Please upload the amended drainage plans attached to this email onto Ocella for **LU/90/20/DOC** for Parcels A2 and B6 at Hampton Park.

Comments;

Paul Cann
Principal Engineer (Drainage)

Type B Manhole

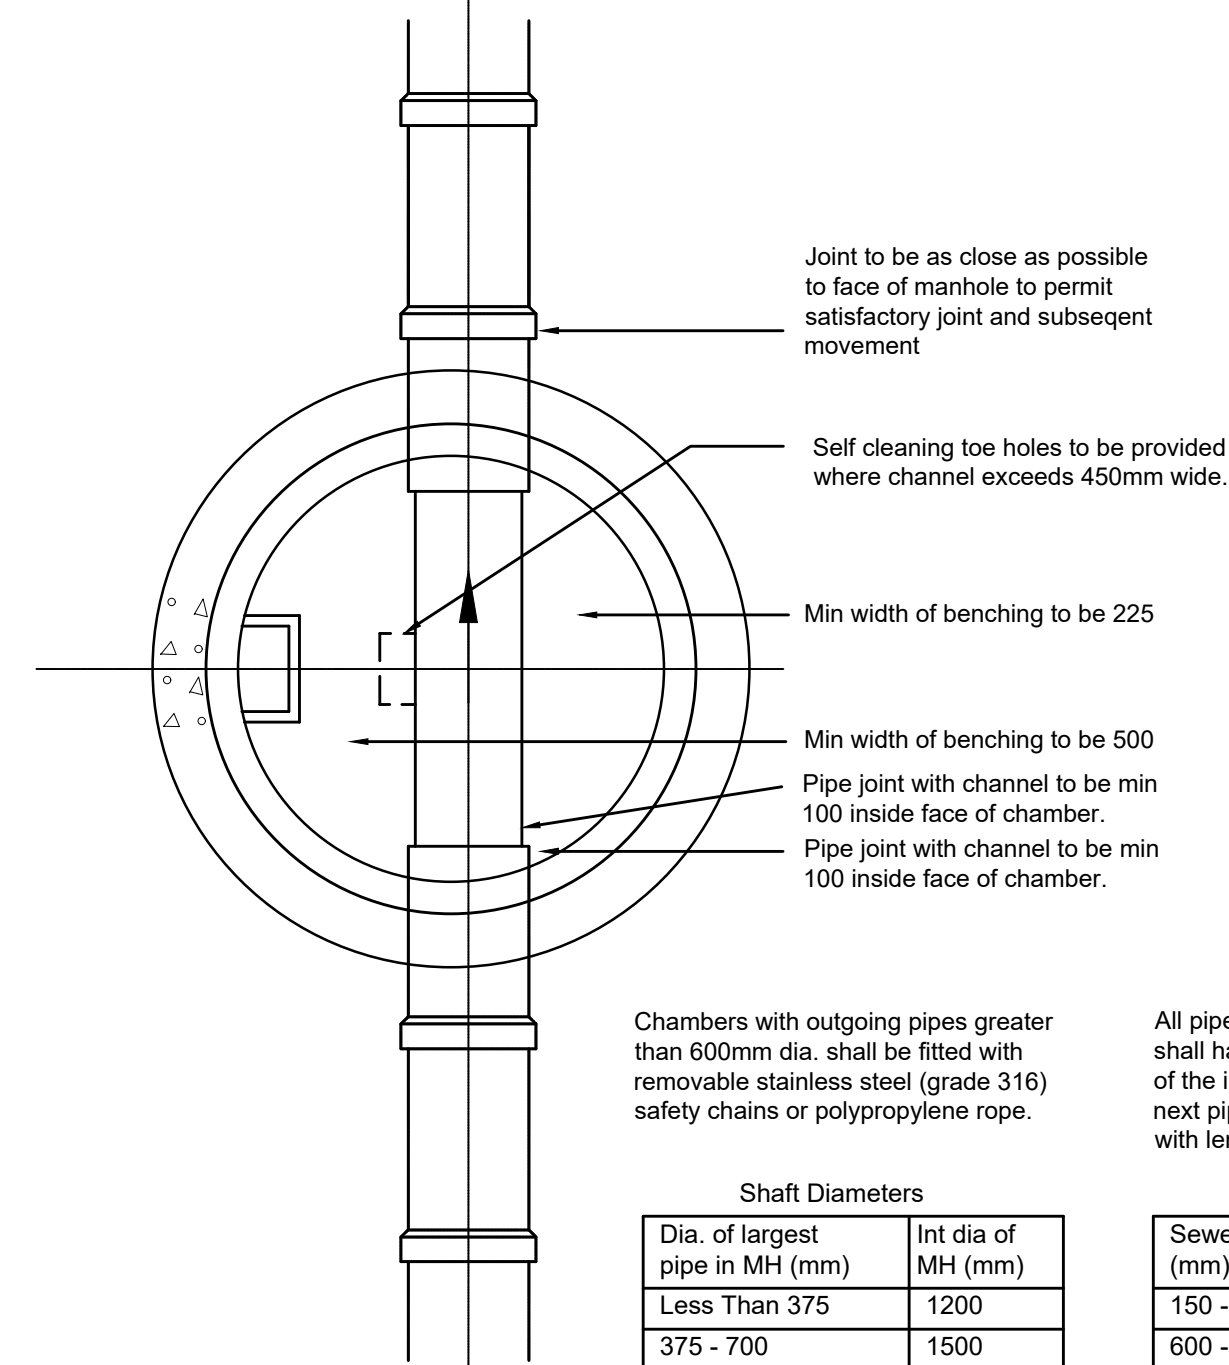
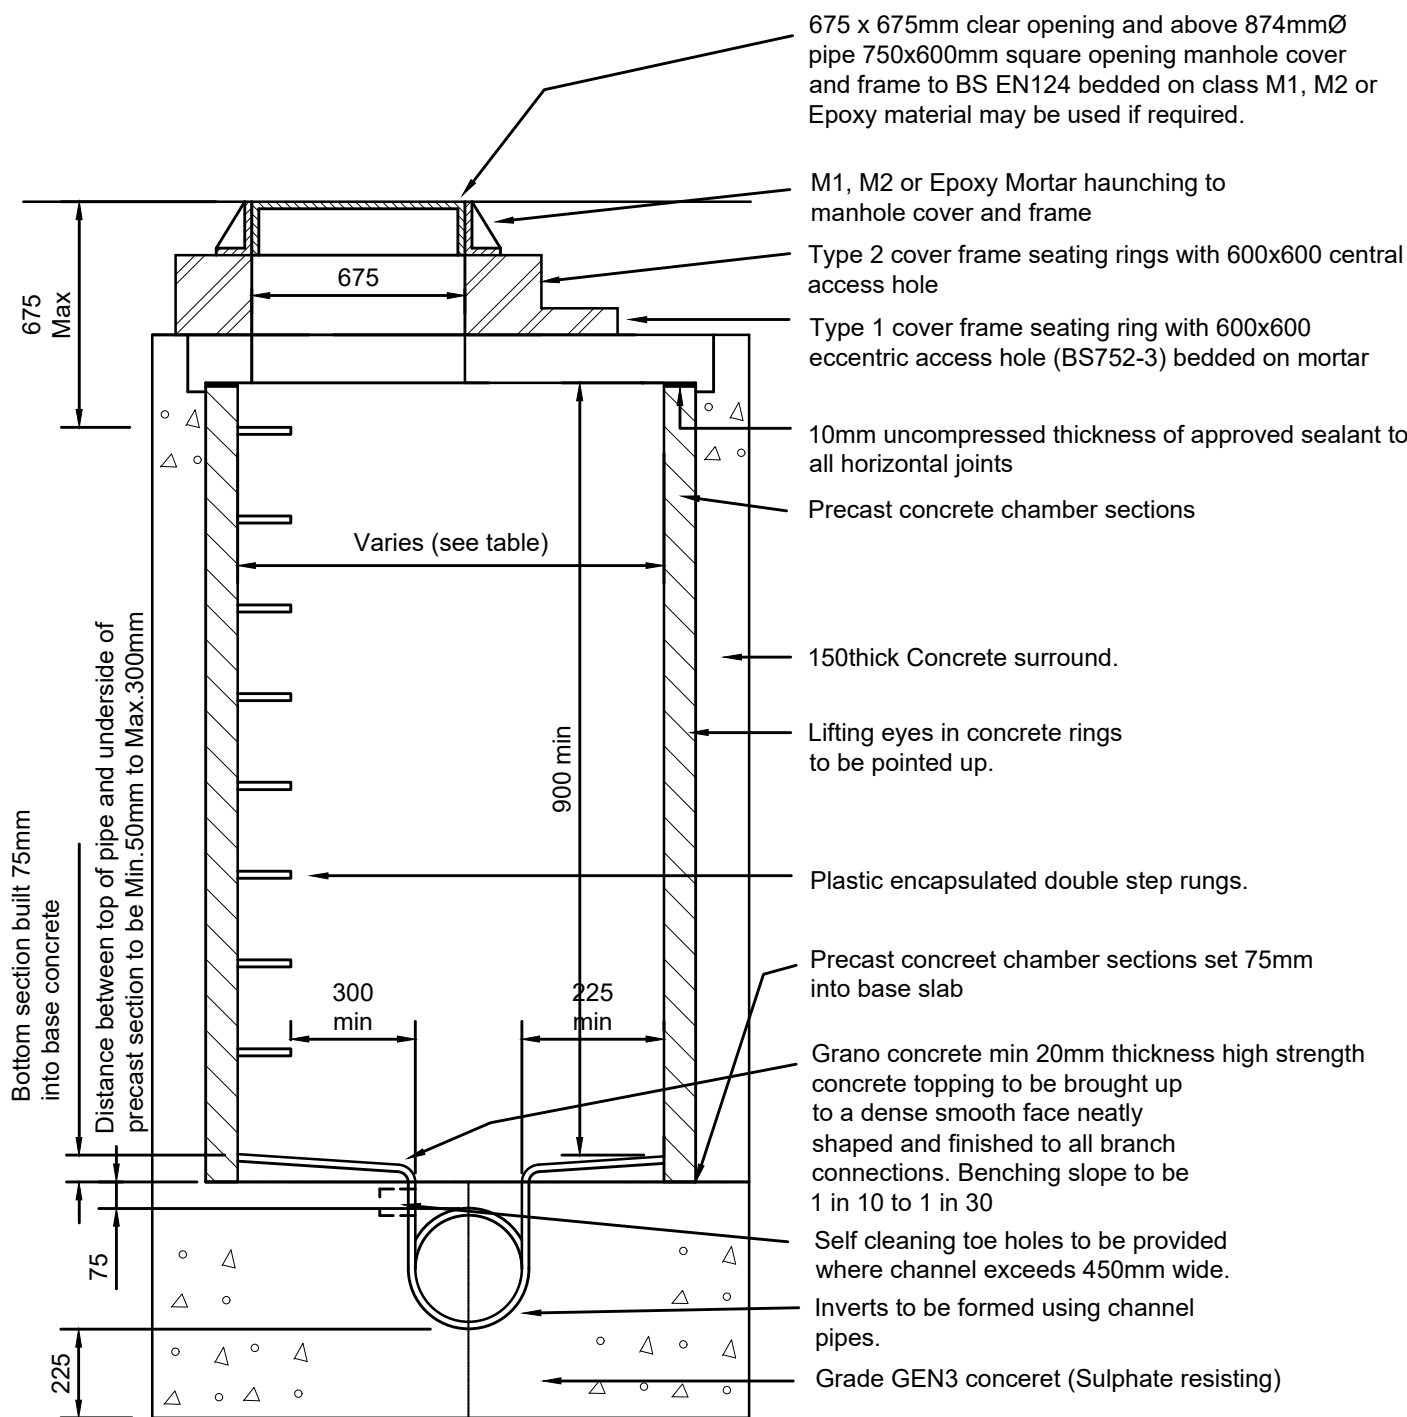
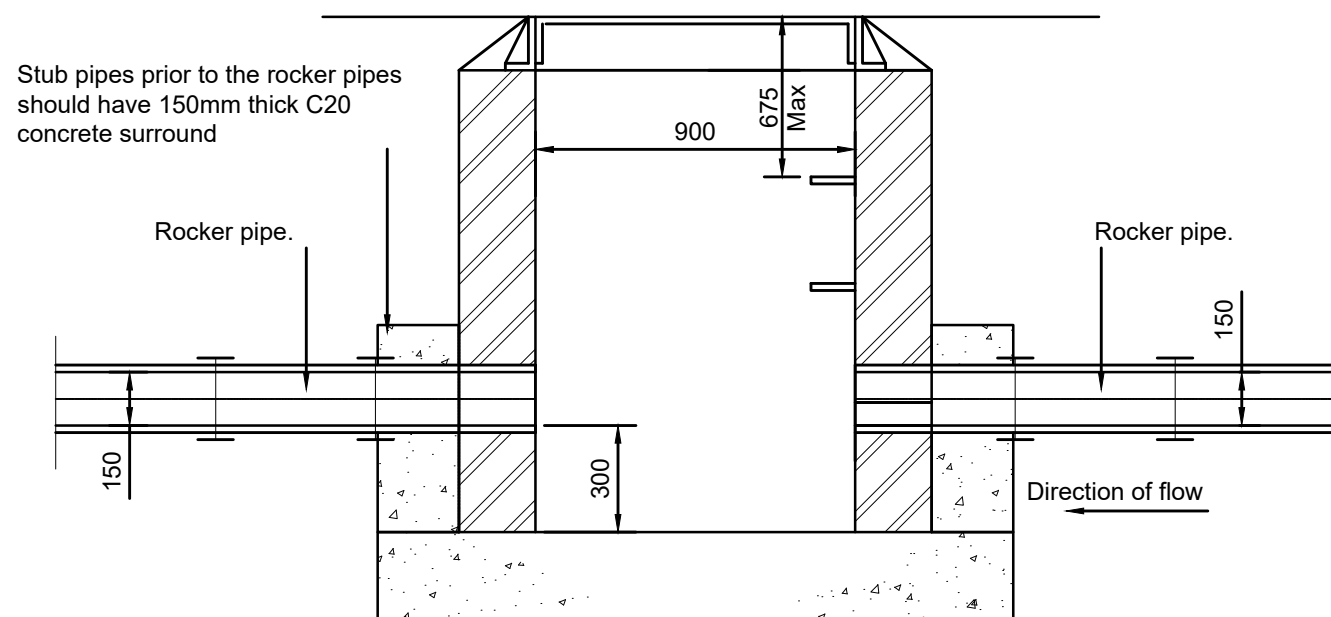
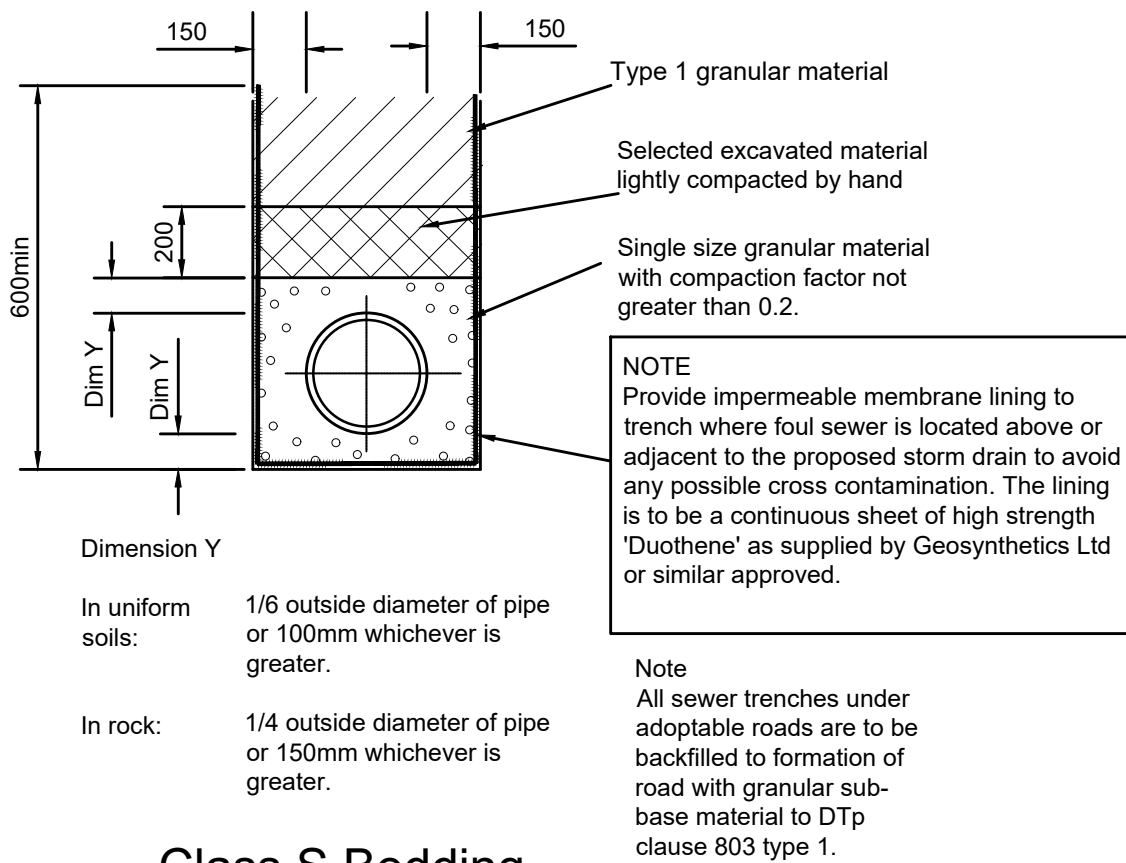
1. CP1 and CP2 (catchpits) on the manhole schedule drawing need to refer to a catchpit detail, not a type B manhole.
2. Provide non adoptable manhole construction details.
